PLANNING AMENDMENT

H08/0440/01

Alterations, new dormer windows etc

Alterations to 2 Wargate Way, Gosberton
Application No:H08/0440/01

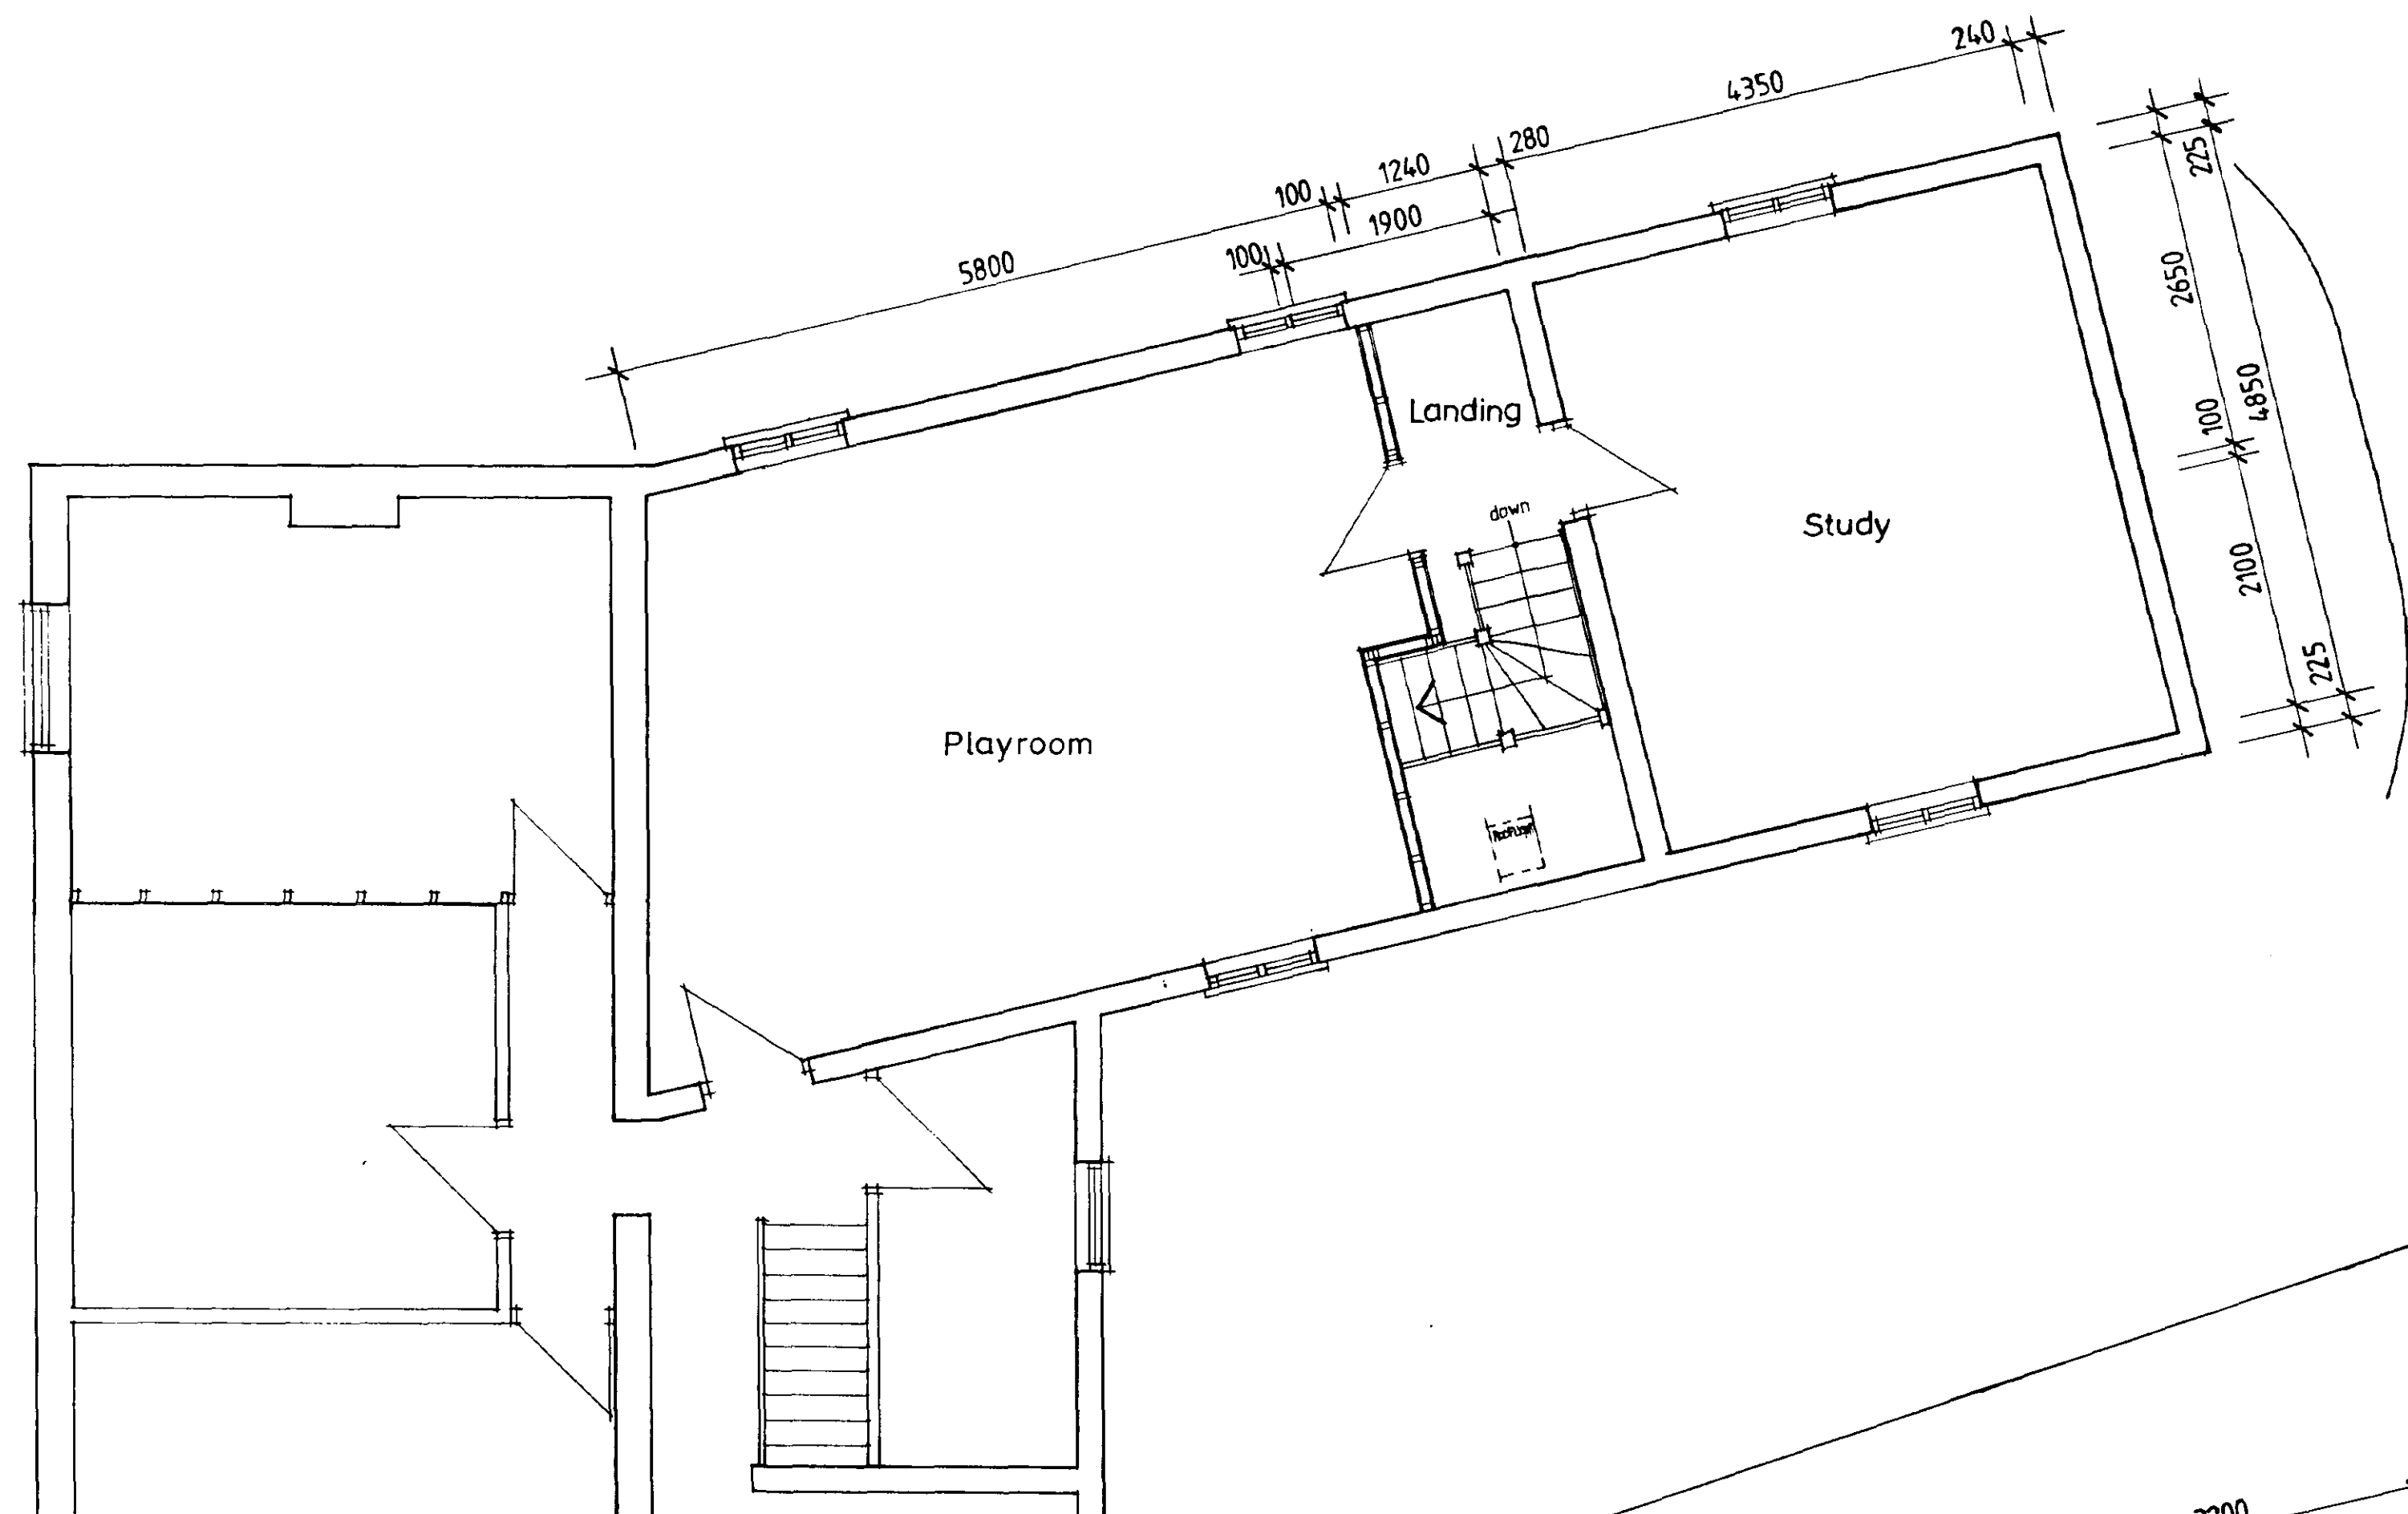
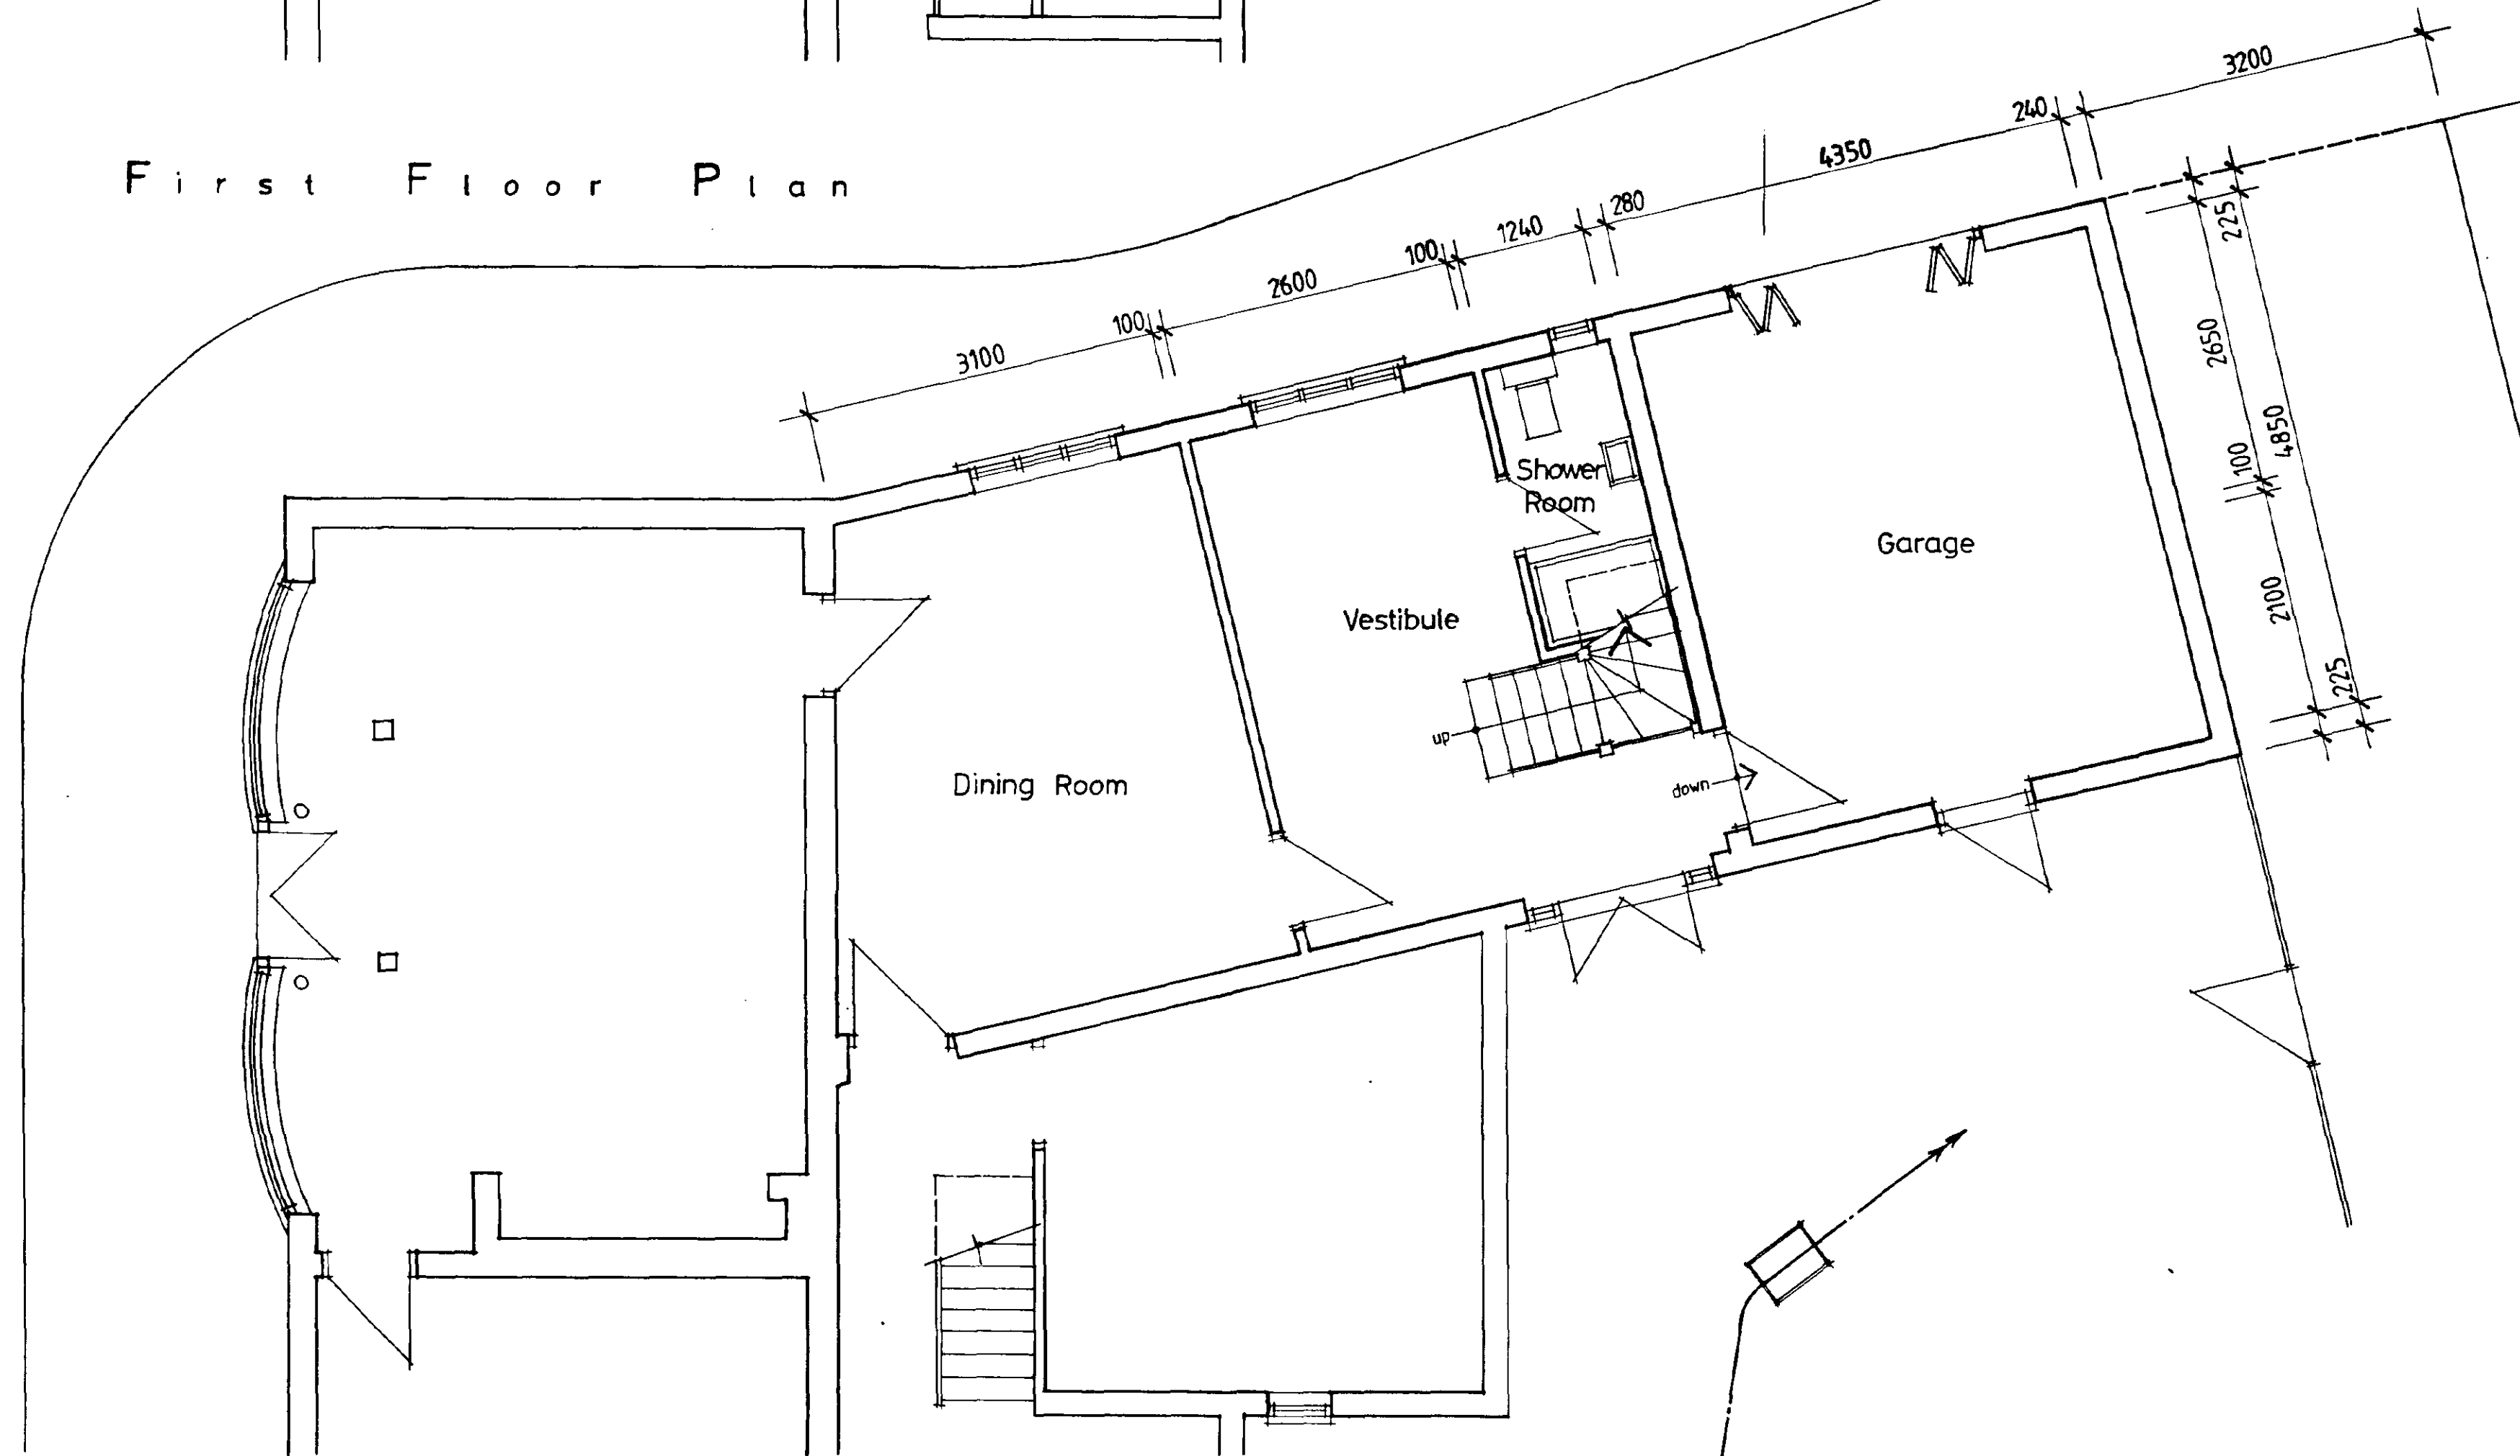
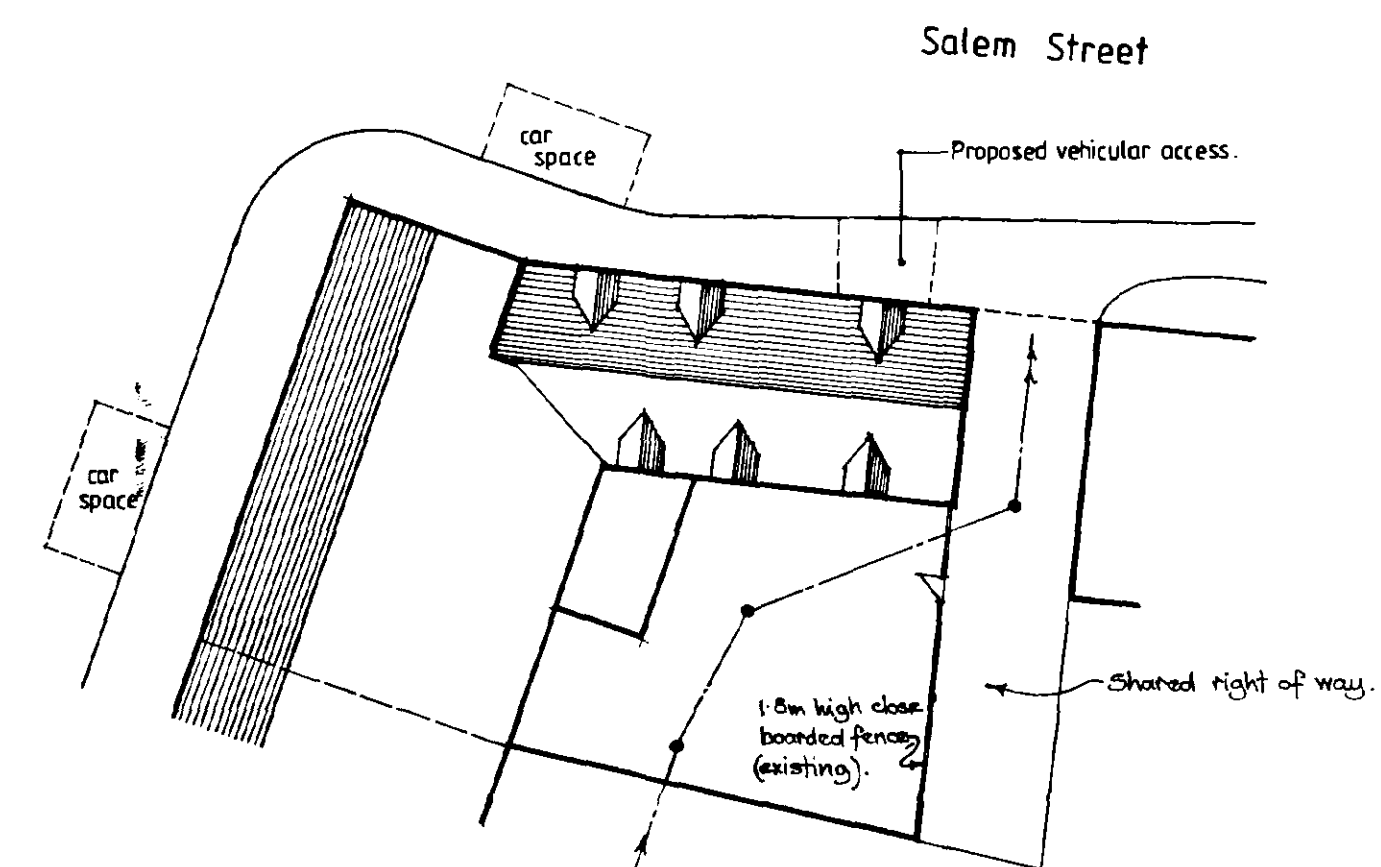
Following my discussions with Mr Roberts and Mr Scrivens I have enclosed 4 copies of dwg no 01030/04 Rev A Proposed elevations, and dwg no 01030/03 Rev A.
